## Department of Transportation

HWY 105/Jackson Creek Pkwy  
Town of Monument

RE: CDR HWY 105/JCP  
CDR - Construction Drawing Review

The State Highway 105/Jackson Creek Parkway - Phase 2 Construction Plans dated February 2023 has been reviewed by the CDOT North Program Traffic Manager, their comments are as follows:

STATE HIGHWAY 105 / JACKSON CREEK PKWY. - PHASE 2 CONSTRUCTION PLANS			
STORMWATER QUALITY FACILITY			
OUTLET BOX DETAILS			
DESIGNED BY	MAW	SCALE	DATE 02-23-23
DRAWN BY	PRA	(H) 1" = N/A	SHEET 17 OF 23
CHECKED BY	(V) 1" = N/A	JOB NO.	1302.22

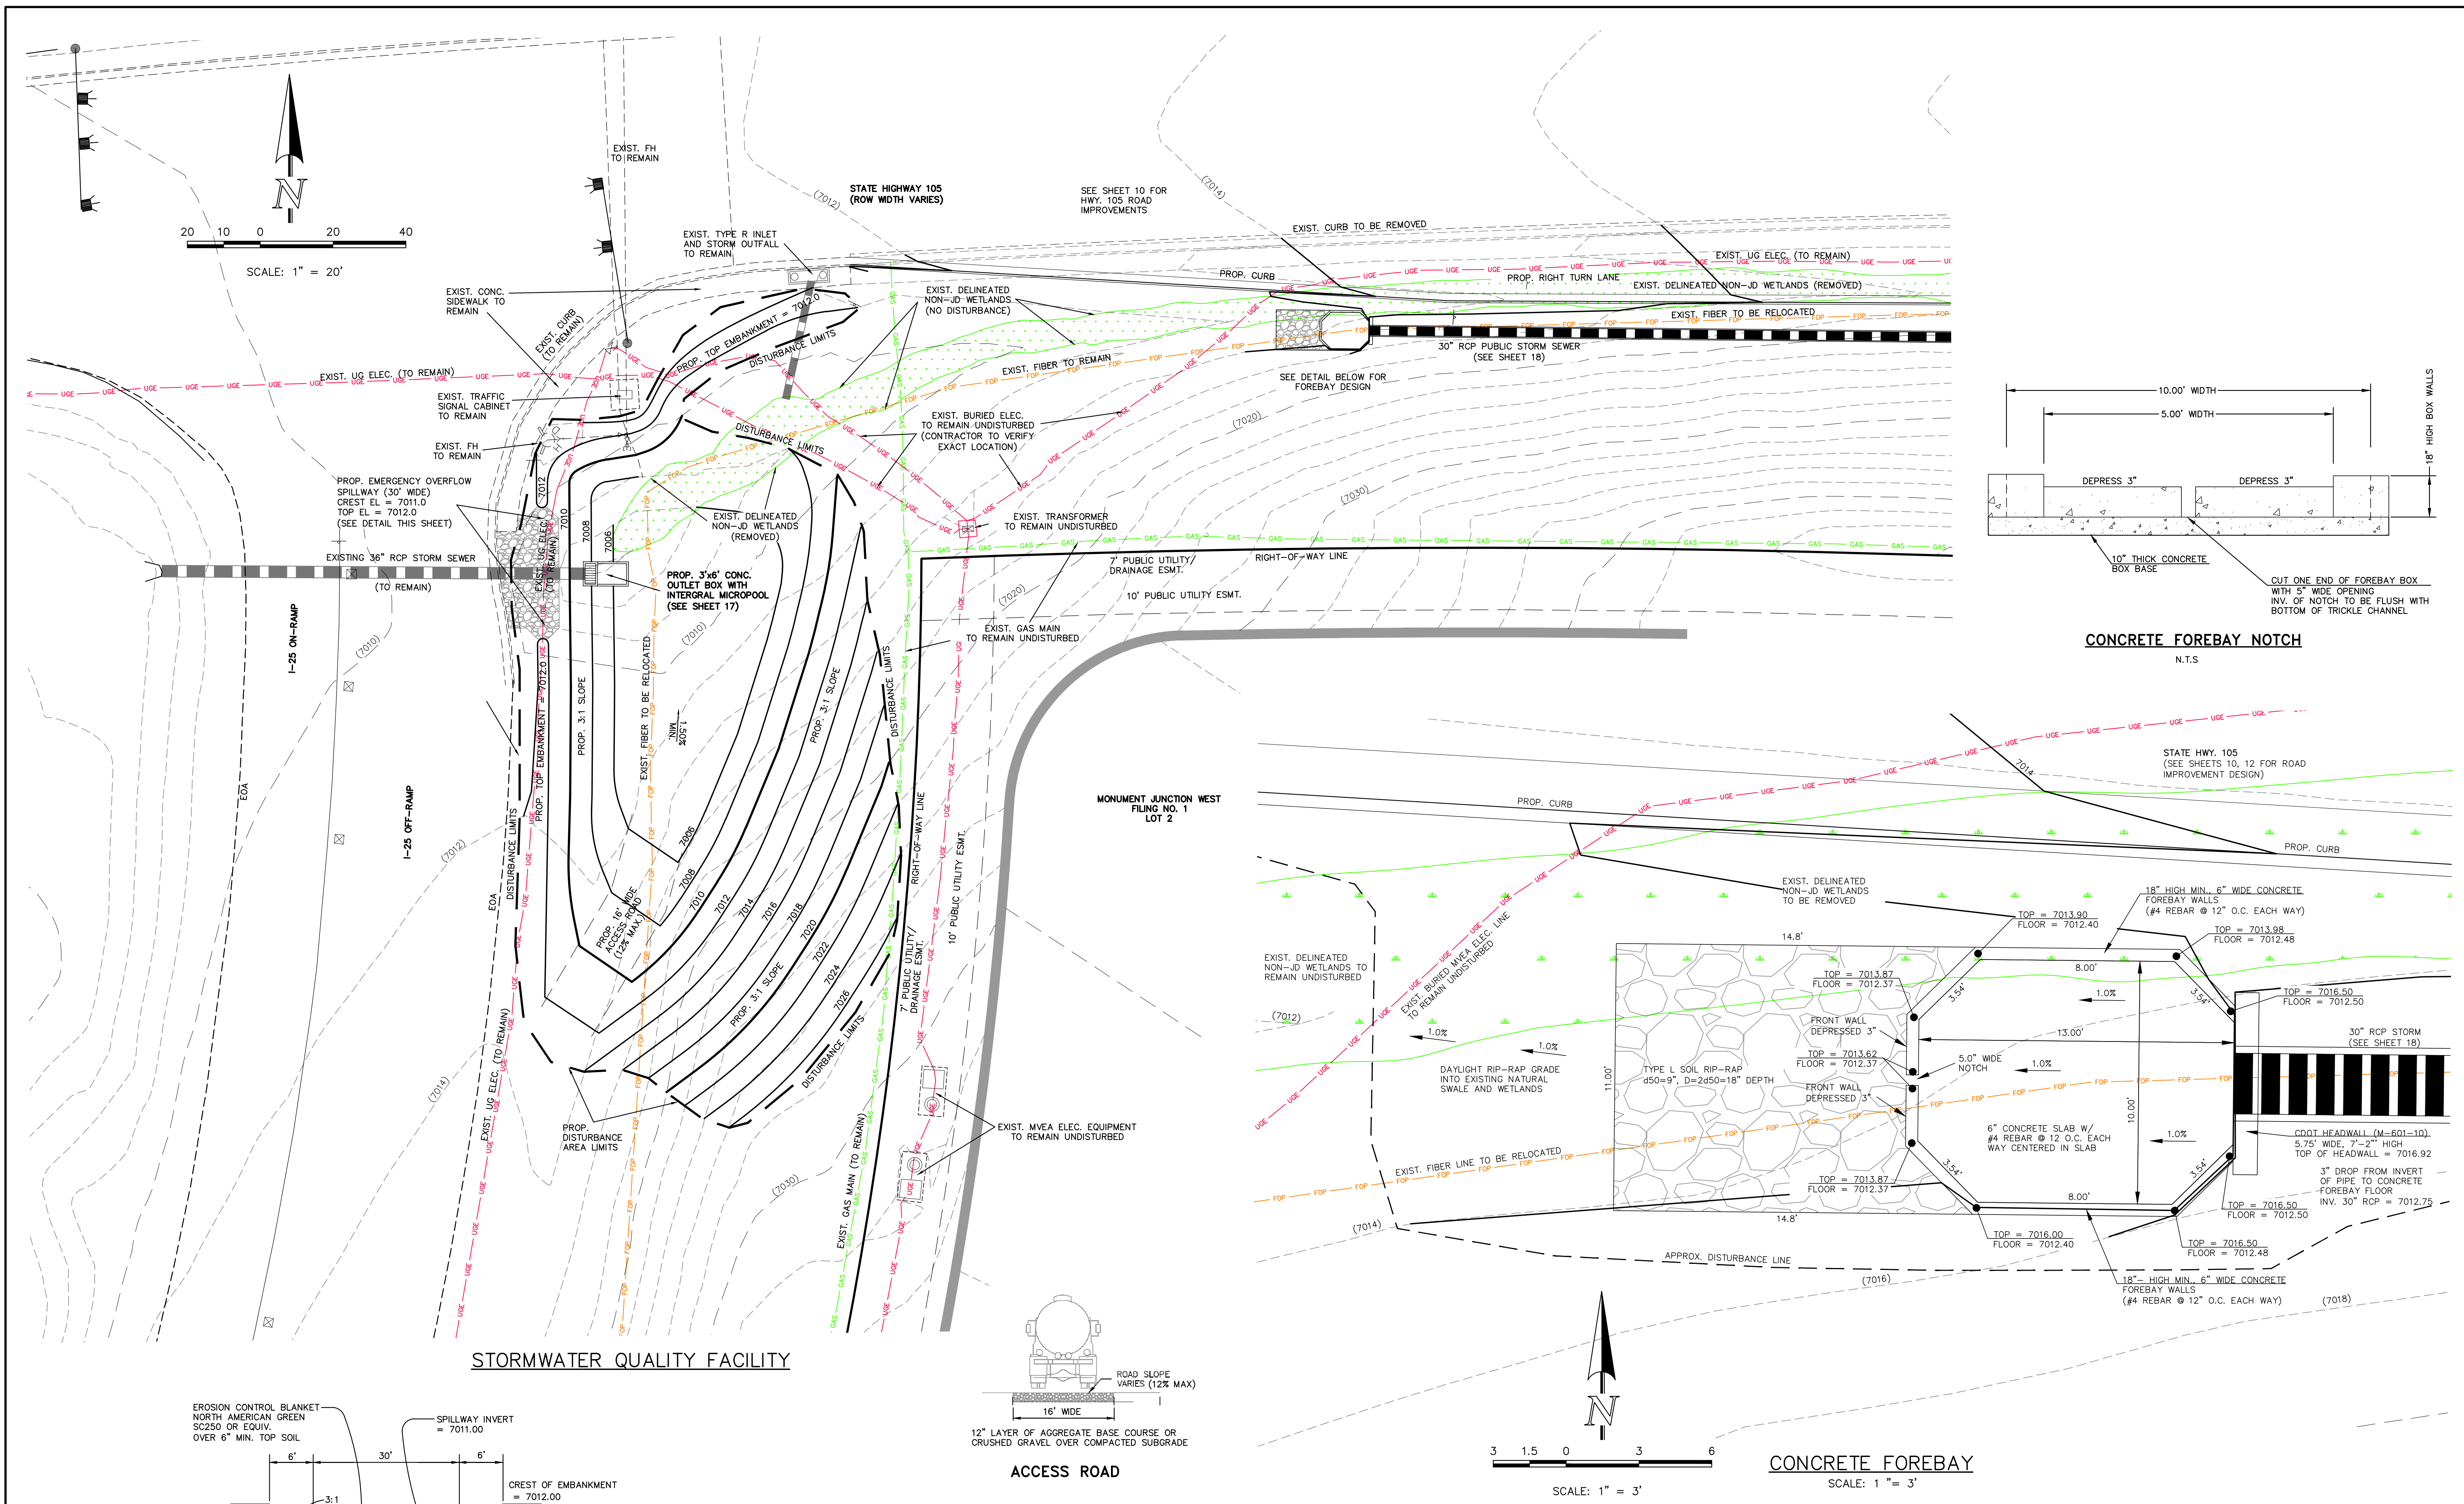
- Comments regarding the stormwater quality facility at the SE corner of Highway 105 and the I-25 On and Off ramps. The new facility will tie into the existing RCP - It is expected that flows will increase into the existing Jackson Creek. What environmental analysis has been done to rectify increased flows and what's being done to protect PMJM habitat from scour in this CDOT property? This property is Part of CDOT's mitigation property for PMJM impacts when the intersection was constructed. Additional wetland delineations are likely required in the CDOT property and at the RCP outlet since this is habitat. USFWS Critical habitat for the PMJM is at the RCP outlet.

- If riprap is the desired solution for the RCP outlet for energy dissipation, the project proponent will need to know the exact sq. footage, as this would be permanent impacts to the PMJM habitat when the Project Proponent consults with the USFWS.

- The pond spillway discharges directly into CDOT ROW. Given the median barrier at the ramp, provide analyses that the inlets along the barrier can meet spread/depth criteria when the pond overtops.
- There does not appear to be 1 foot of freeboard above the 100-yr WSEL at the emergency spillway. Based on the results shown in the plans, less than 1 foot is provided.
- Provide outlet protection necessary at the outlet of the existing 36" RCP culvert. Based on velocities reported in the drainage report (over 9 fps), outlet protection would be warranted.
